REQUEST

Current Zoning: N1-A (neighborhood) and MUDD-O (mixed-use development district, optional)
Proposed Zoning: MUDD-O (mixed-use development district, optional) and MUDD-O SPA (mixed-use development district, site plan amendment)

The petition proposes expansion of an existing pet services indoor/outdoor use on current and adjoining site. The expansion will increase the size from 6,000 square feet to up to 8,500 square feet of gross floor area with additional limited outdoor pet services uses.

Staff recommends approval of this petition.

SHEET TITLE
REZONING PLAN: PETITION # 2023-007

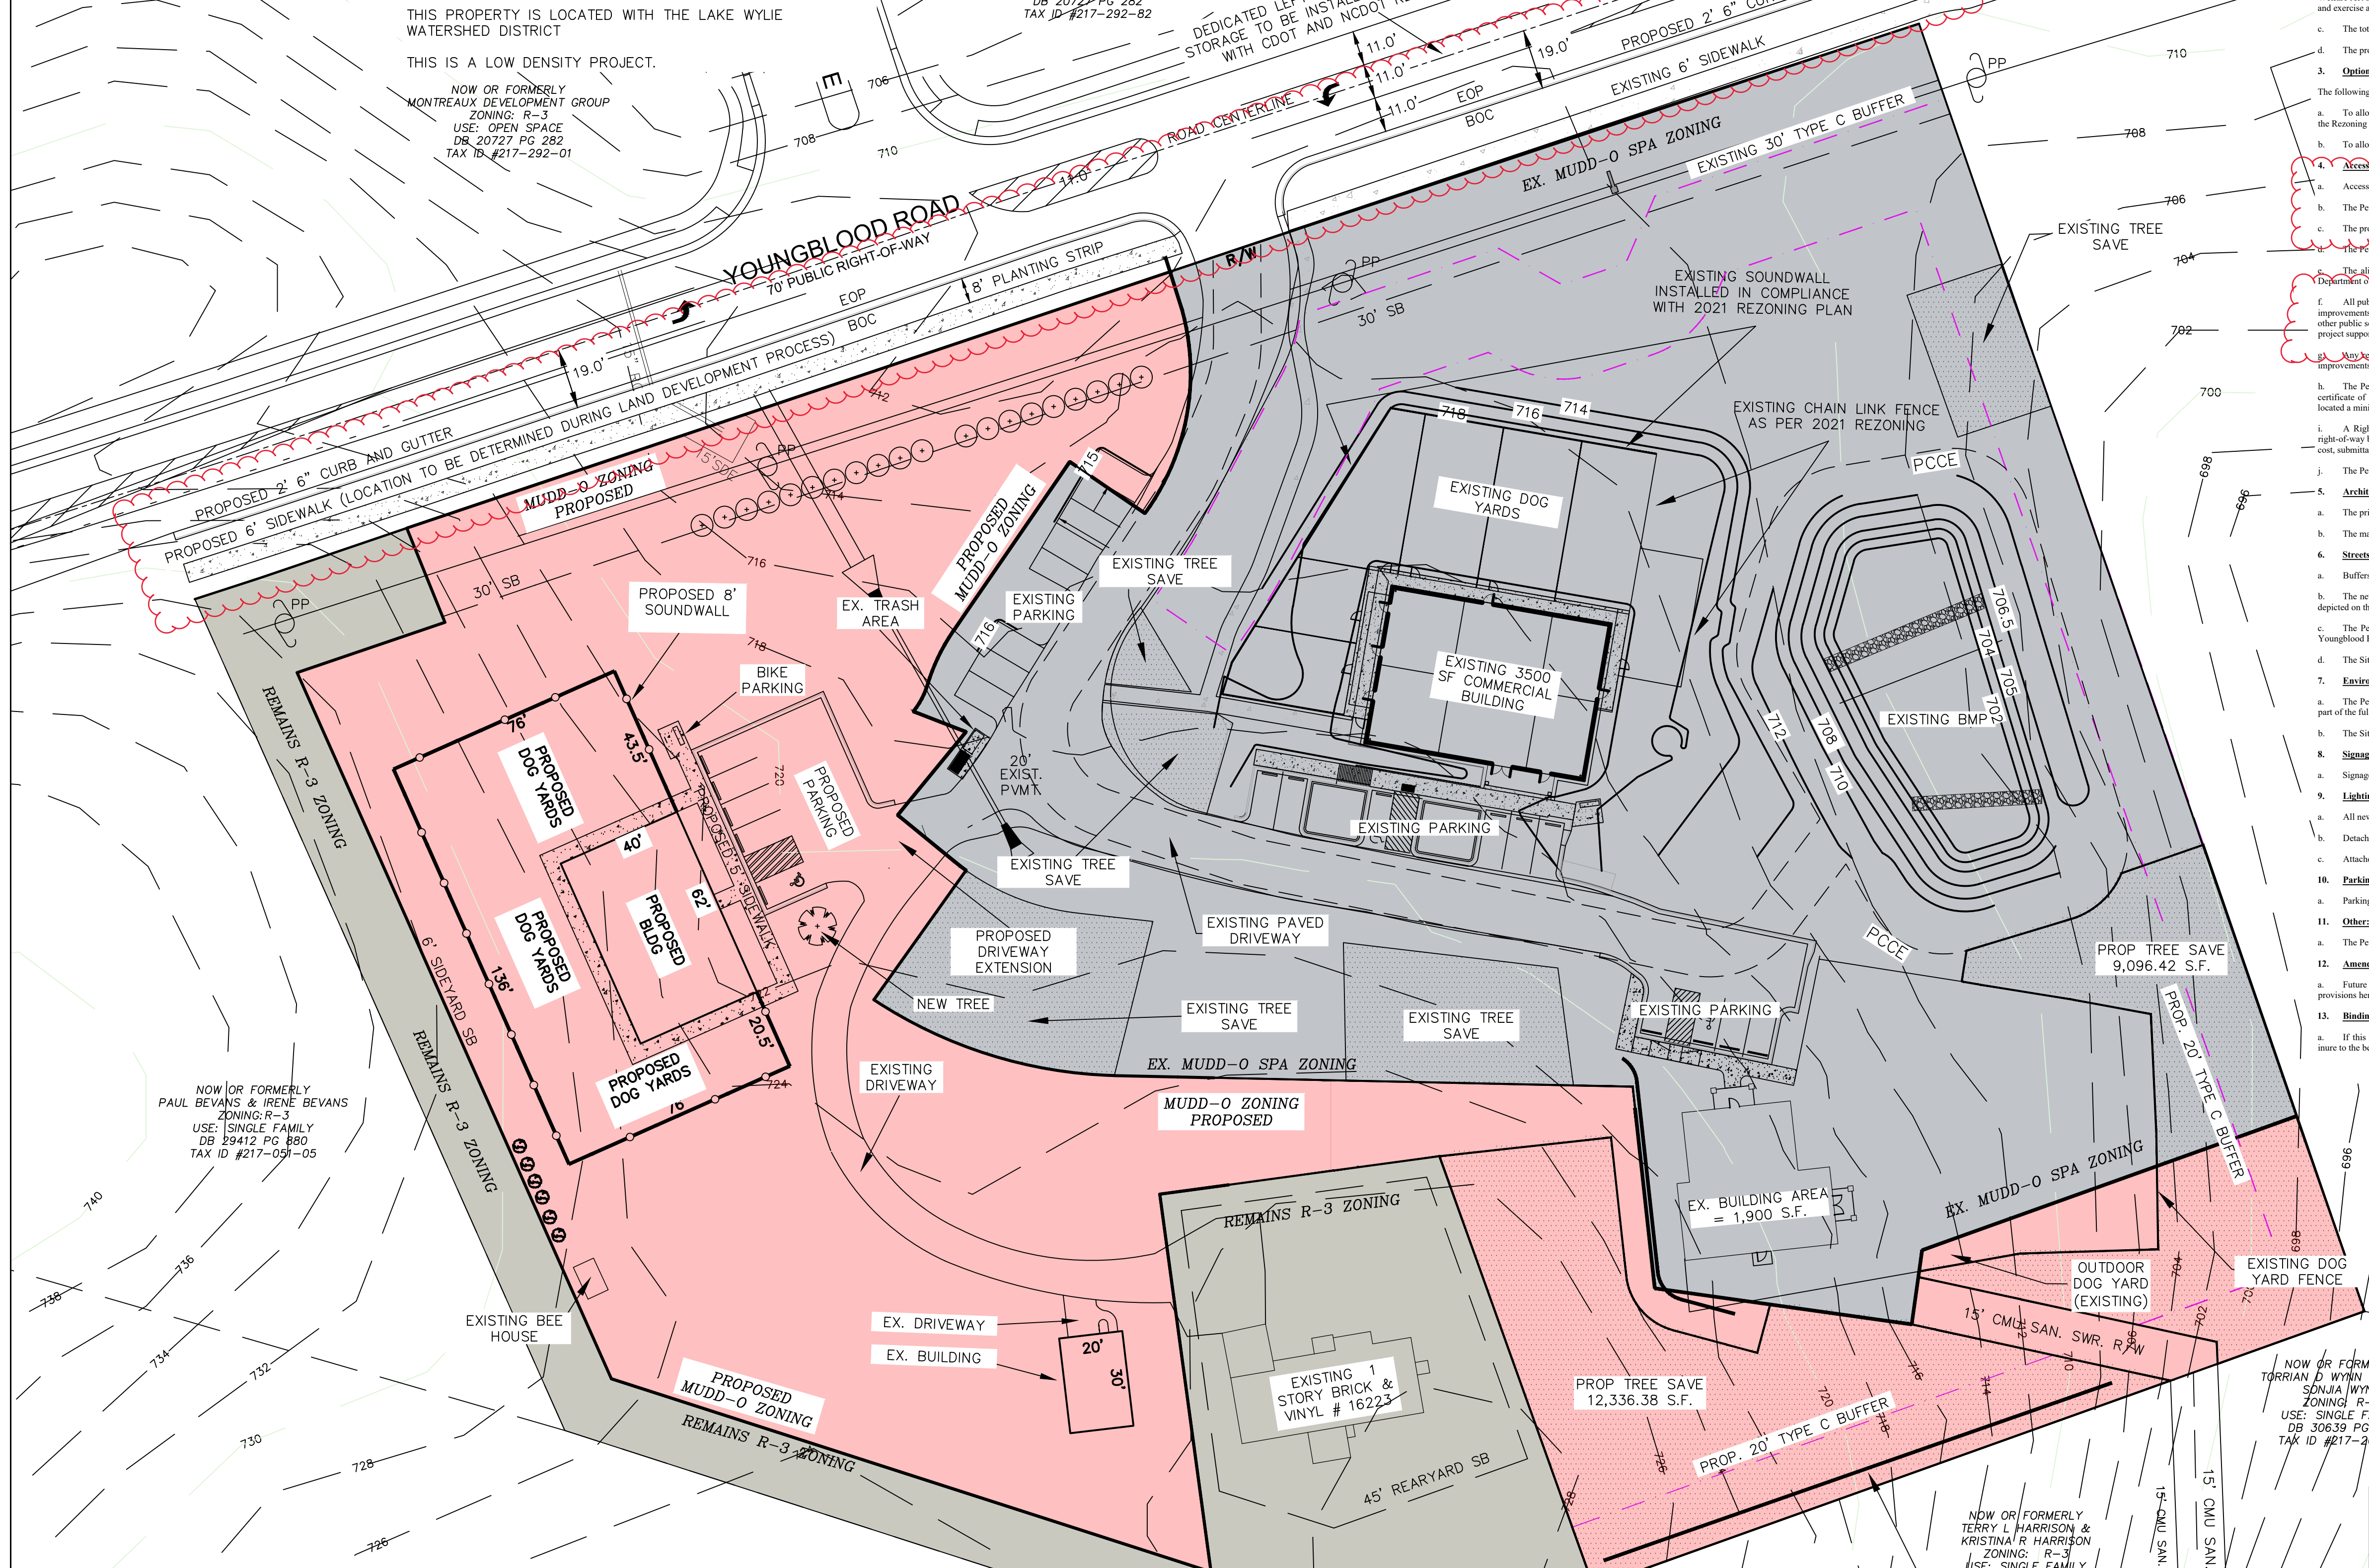
1. ~~Youngblood Road: Location of curb and gutter to be moved to 19 feet from roadway centerline to accommodate the Charlotte Streets Map with a roadway typical section of a 2+ avenue with an 8-foot planting strip and a 12-foot multi-use path. Label and dimension the curb and gutter from the centerline for each road on the site plan.~~ Addressed

2. ~~Revise site plan and conditional note(s) to commit to installing a left turn lane on Youngblood Road with 100 feet of storage.~~ Addressed
 3. ~~Add conditional note specifying "All public roadway improvements will be subject to the standards and criteria of CDOT and NCDOT, as applicable, to the roadway improvements within their respective road system authority. It is understood that such improvements may be undertaken by the Petitioner on its own or in conjunction with other development or roadway projects taking place within the broad southwestern Mecklenburg area, by way of a private/public partnership effort or other public sector project support."~~ Addressed
-
